From: Liz Rogers [REDACTED]
Sent: 30 March 2017 11:37
To: Planning.Responses
Cc: Simon Davis
Subject: Planning Consultation on Y/15/17/DOC

App No: Y/18/17/DOC

Proposal: Application for approval of details reserved by condition imposed under Y/64/16/PL relating to conditions
5-landscape scheme for HGV parking site, 6-landscape scheme along southern boundary, 7-site
management plan and 10-light appliances.

Address: Land to the North of John Turner P Lake Lane Barnham PO22 0AL

EXTERIOR LIGHTING LAYOUT

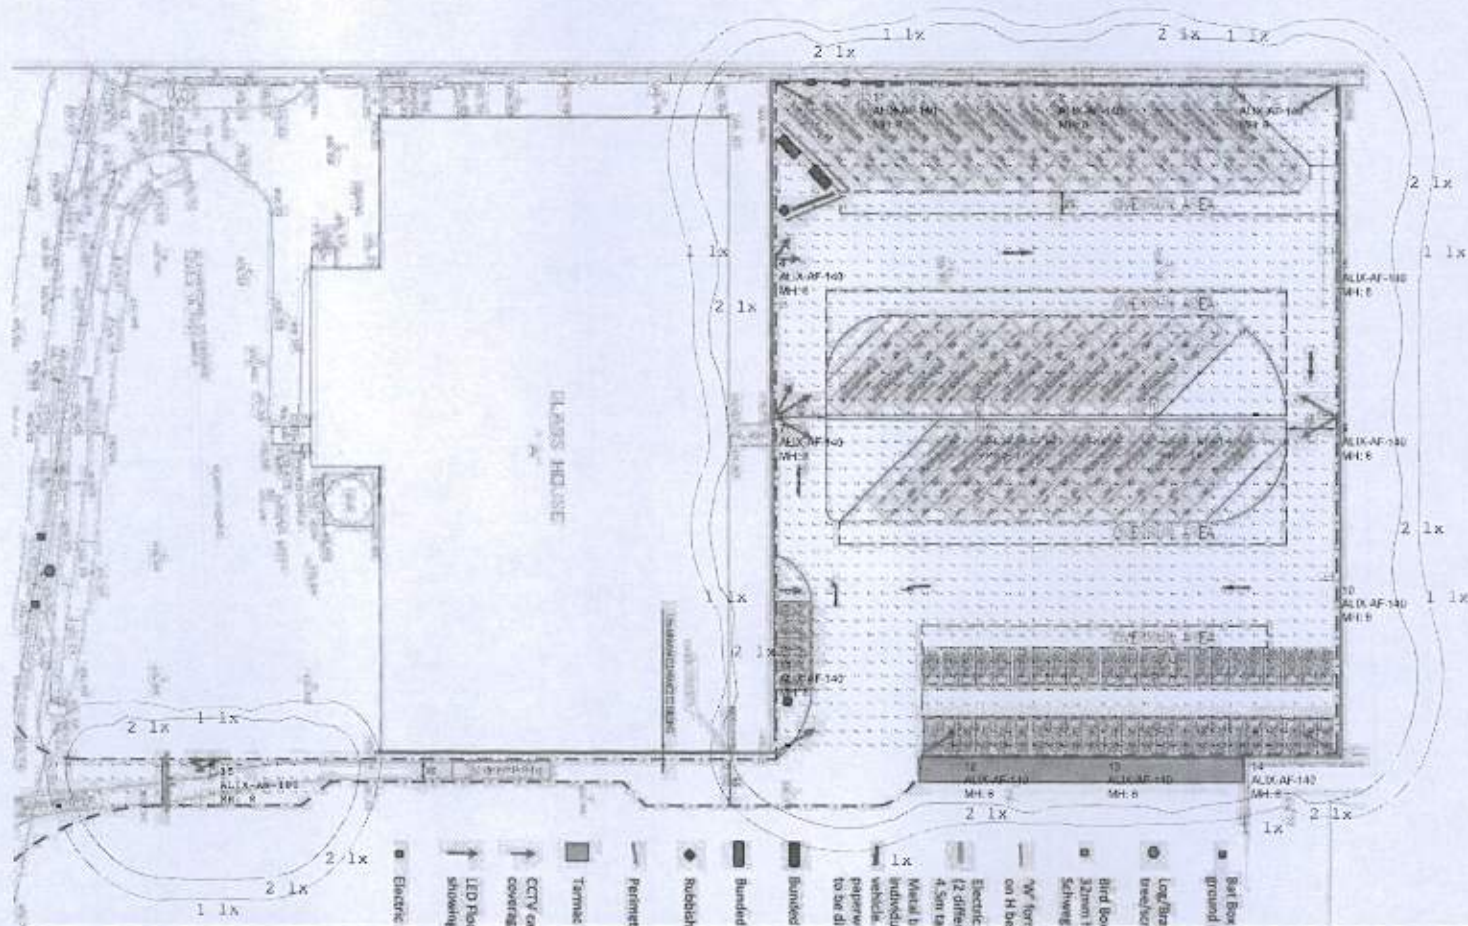
Following review of the lighting plans submitted we are happy for condition 10 to be discharged.
